**SSI-48492458 for Waratah Super Battery at Station Road, Colongra
(Lot 10/ DP1201414)**

19 December 2022

TfNSW has reviewed the proposal and supporting documentation submitted and **is not satisfied** the proposed development has adequately addressed the anticipated construction traffic impacts on the classified road network.

Intersection of Pacific Hwy and Wyee Rd, Doyalson

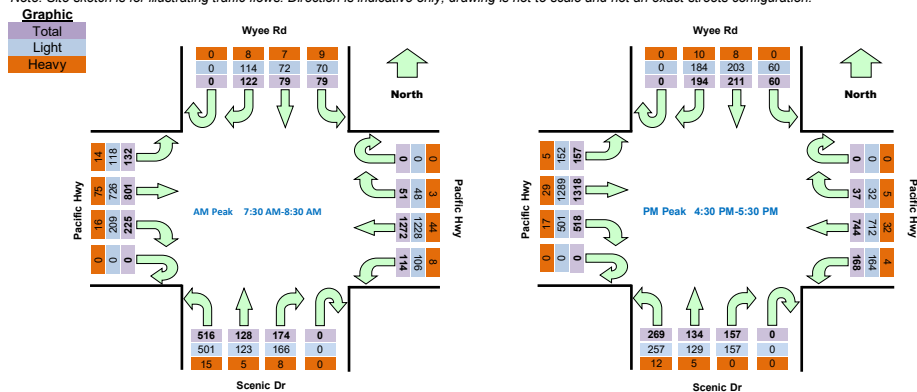
- This existing key intersection is clearly demonstrated in the EIS and SIDRA Outputs (Appendix I) to be under strain or nearing capacity during the peak hours. Additionally, the construction traffic of the development is demonstrated to place the intersection under further strain. No mitigation measures have been provided to directly address this traffic impact. It is noted:
 - Construction workforce is stated to be likely based on the Central Coast or in Sydney or Newcastle and has the potential to access the site from all directions, including through this key intersection.

- Appendix I – Traffic Data
 - Presents SIDRA outputs as extracts only, which are extremely small text, without relevant footnotes and does not include any intersection diagrams.

Figure 6 - Peak Hour Construction Vehicle Trips (from Environmental Impact Statement)

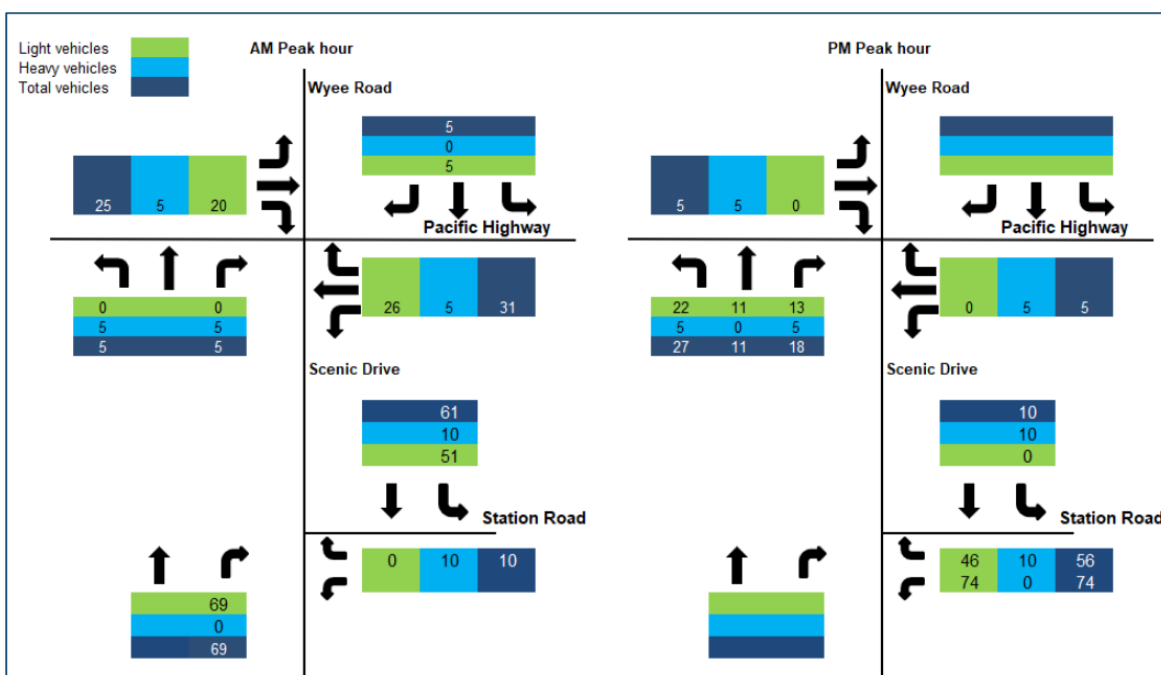
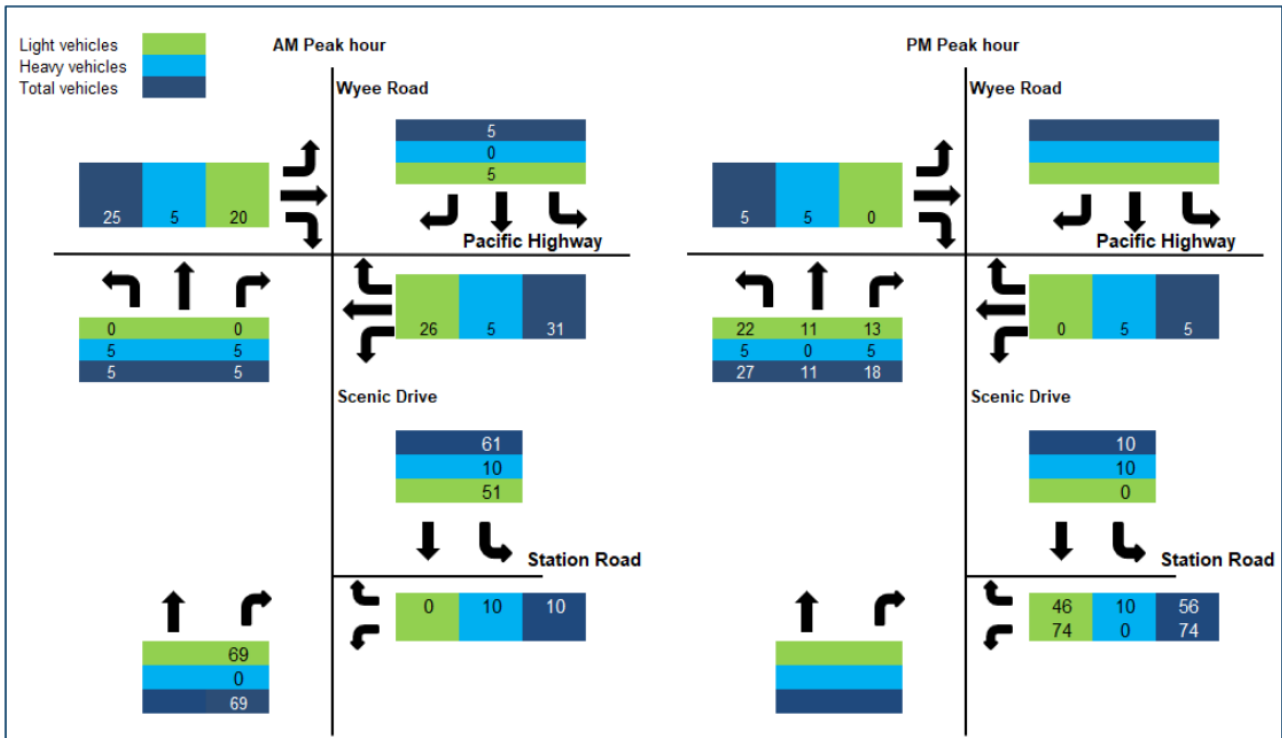
- The SIDRA traffic volumes do not appear to match those in the traffic distribution tables in the EIS (figures 6.21 & 6.23). It is unclear which is correct. This information needs to be updated.

- The SIDRA analysis, directional traffic diagrams and traffic assessments need to be updated to further address the potential additional traffic impacts of any additional workforce accessing / departing the site for testing and / or operational activities required for the first stage of development (initial 350MW) concurrent to the construction staff working on the remaining 500MW of the development.
